DEPARTMENT OF PUBLIC WORKS

MEMORANDUM

TO: All Staff
FROM: Public Works Plan Review Team
DATE: June 6, 2022
SUBJECT: CU-22-00002 Calvary Ellensburg

Calvary Ellensburg Proposed Site Plan Phase I - Exhibit B

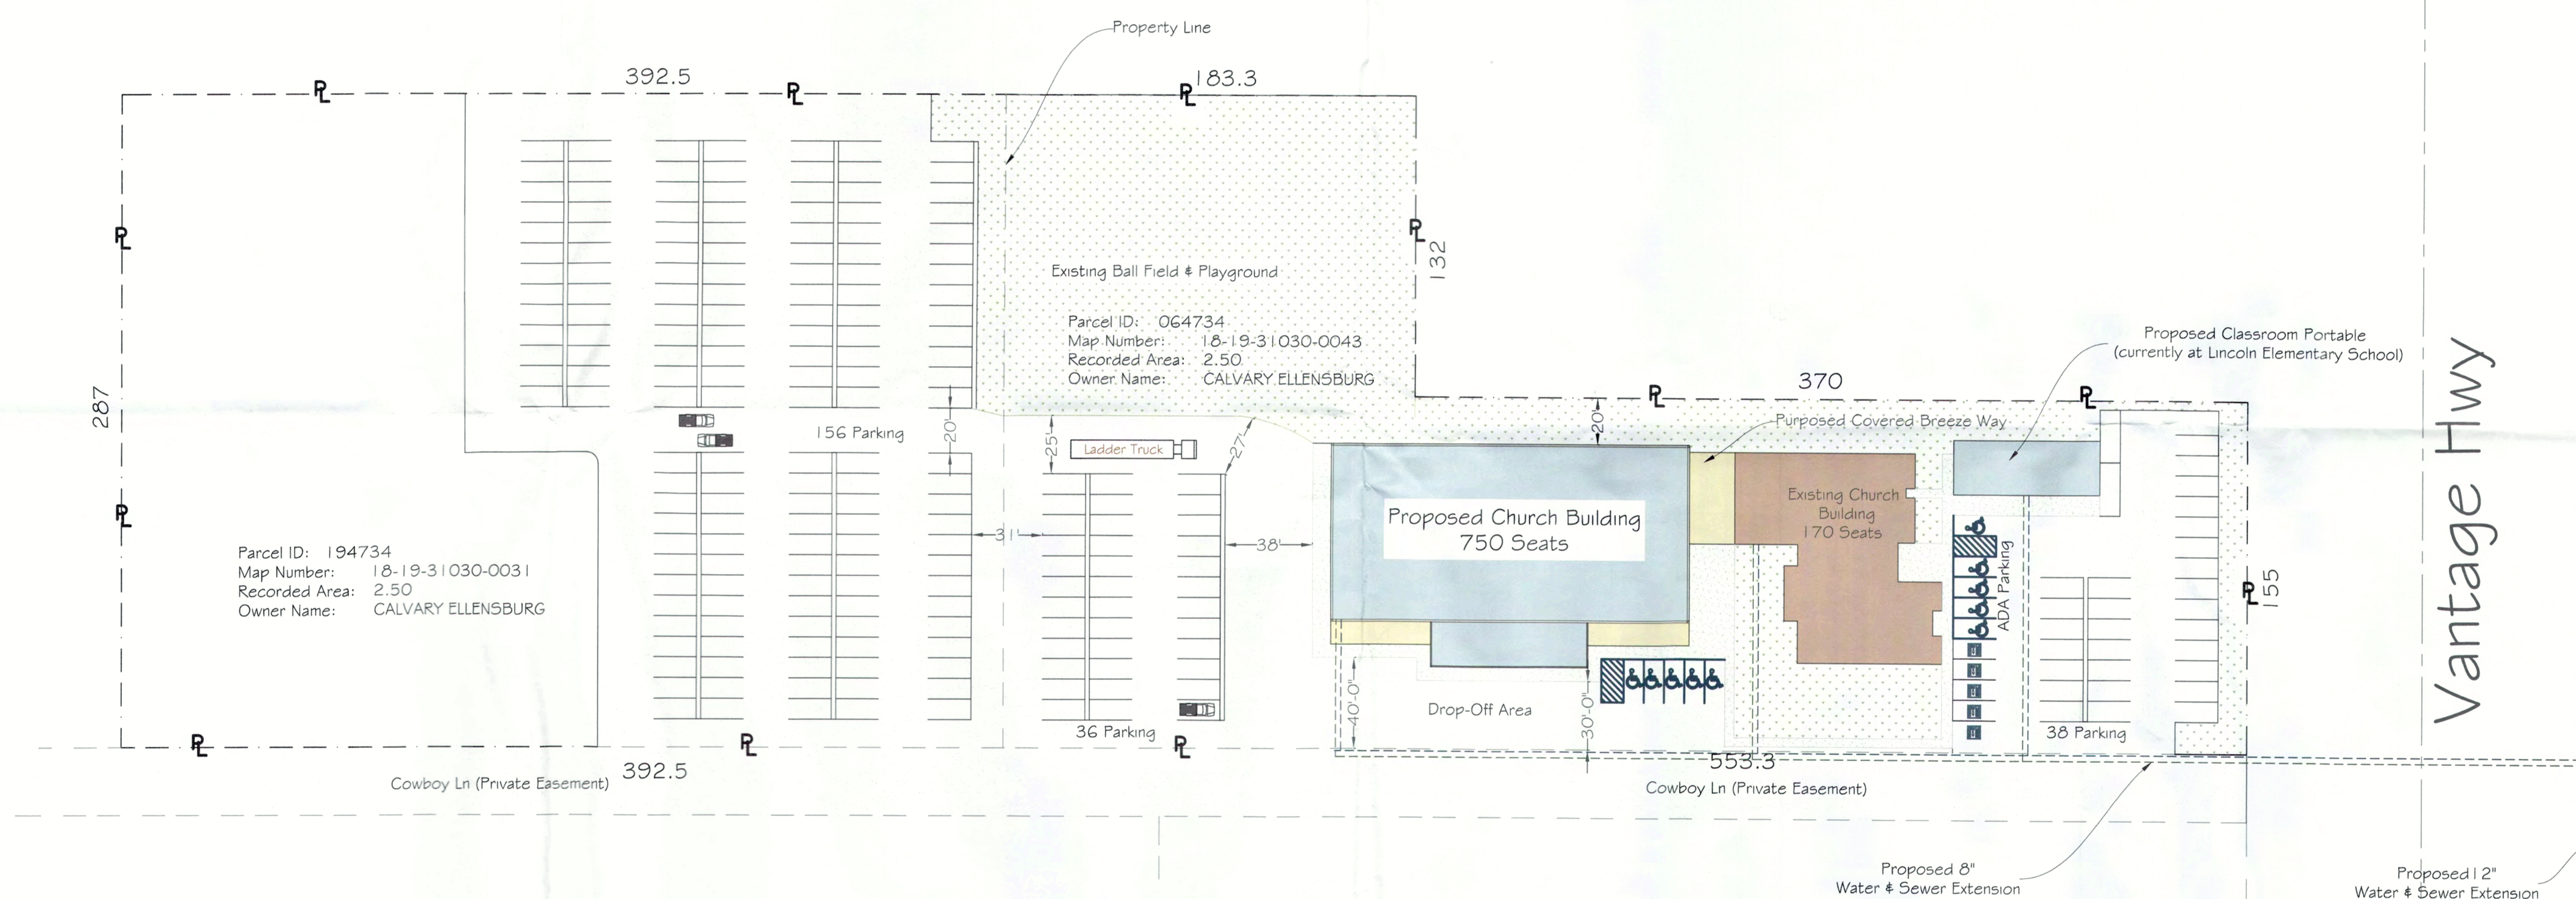
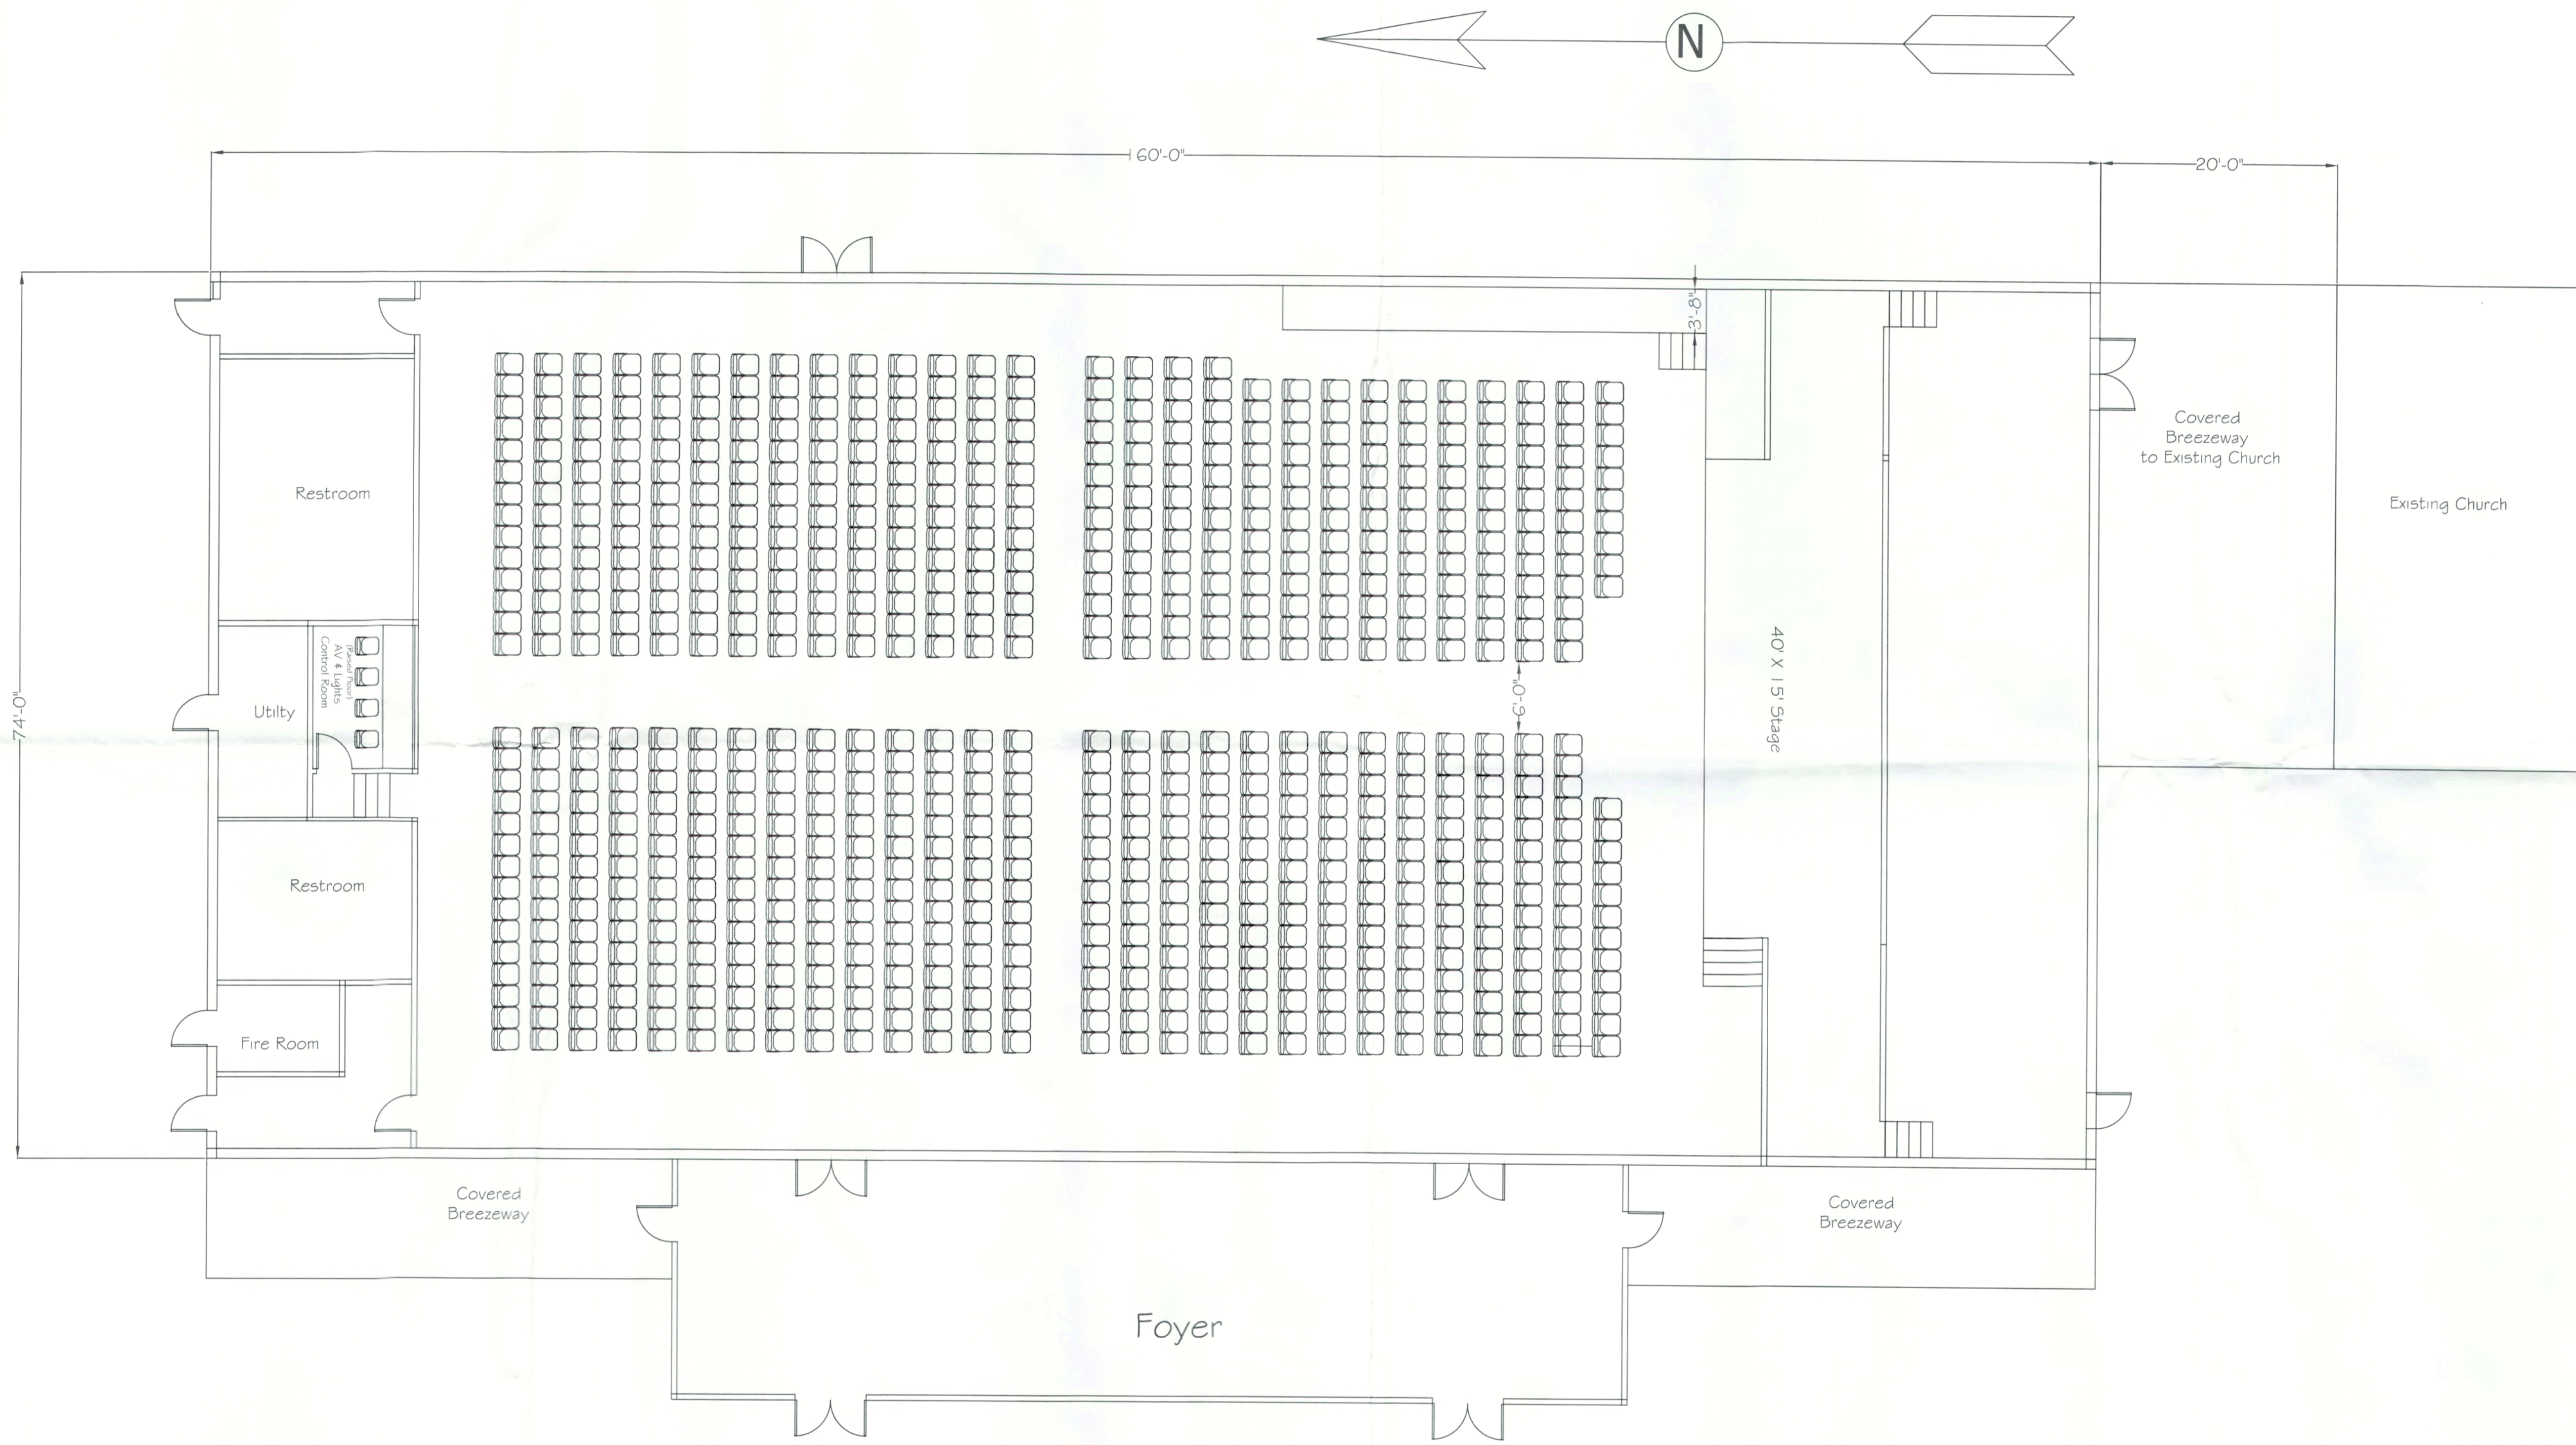
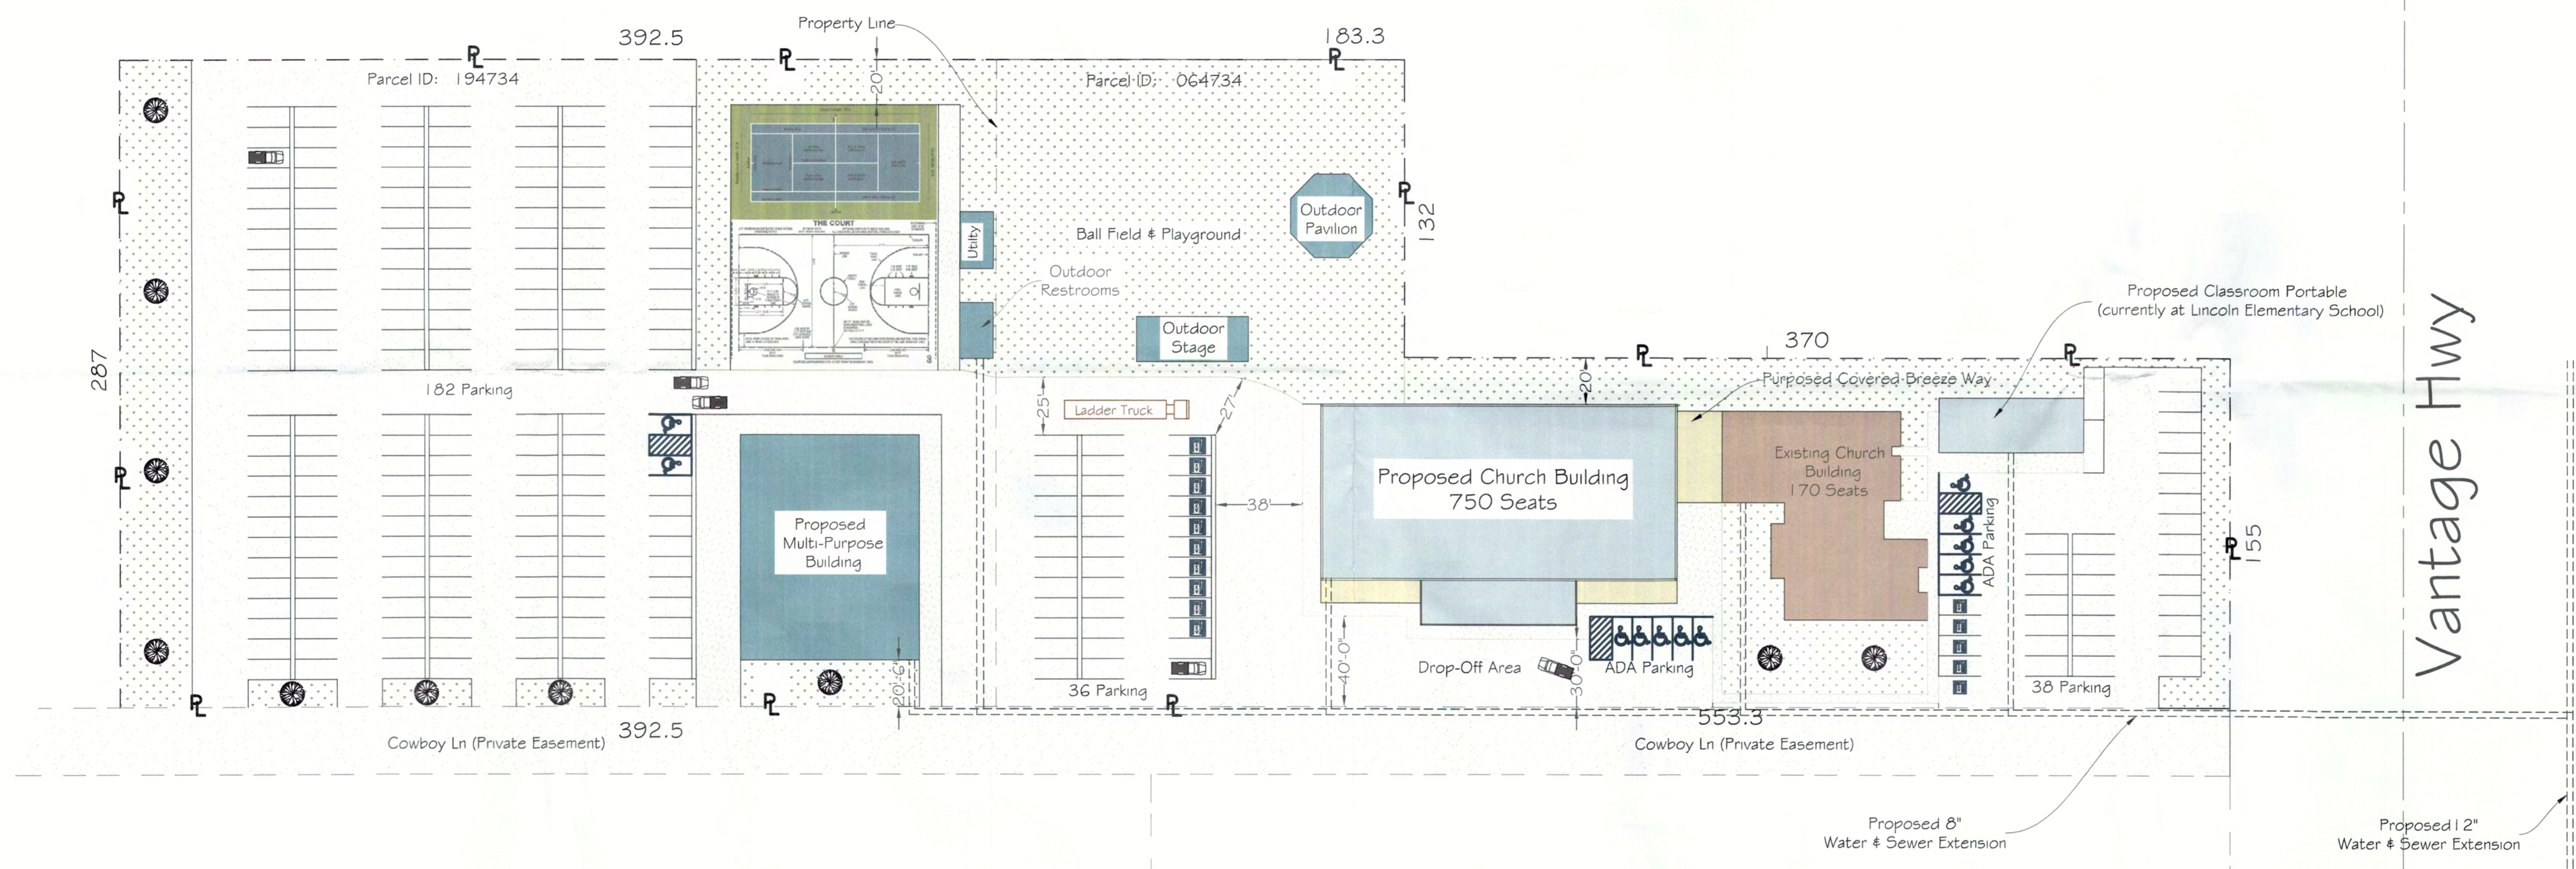
- a. Traffic Concurrency evaluation will be required for this project. A Transportation Impact Analysis (TIA) may be required for all development that will generate more than nine (9) peak hour vehicle trips unless the requirement for a study has been waived by the Public Works director (KCC 12.10.040).

- d. Except as exempted in Section KCC 14.05.060, no grading or filling upon a site involving more than one hundred (100) cubic yards shall be performed without a grading permit from the County Engineer or Public Works designee (KCC 14.05.050). An application for grading in excess of five hundred (500) cubic yards shall be accompanied by an engineered grading plan (KCC 14.05.080).

- e. Engineered stormwater plans are required if the project generates an impervious surface exceeding 5000 square feet. The stormwater system will comply with the Stormwater Management Manual for Eastern Washington (SWMMEW). Please submit the stormwater plans to Public Works for review.
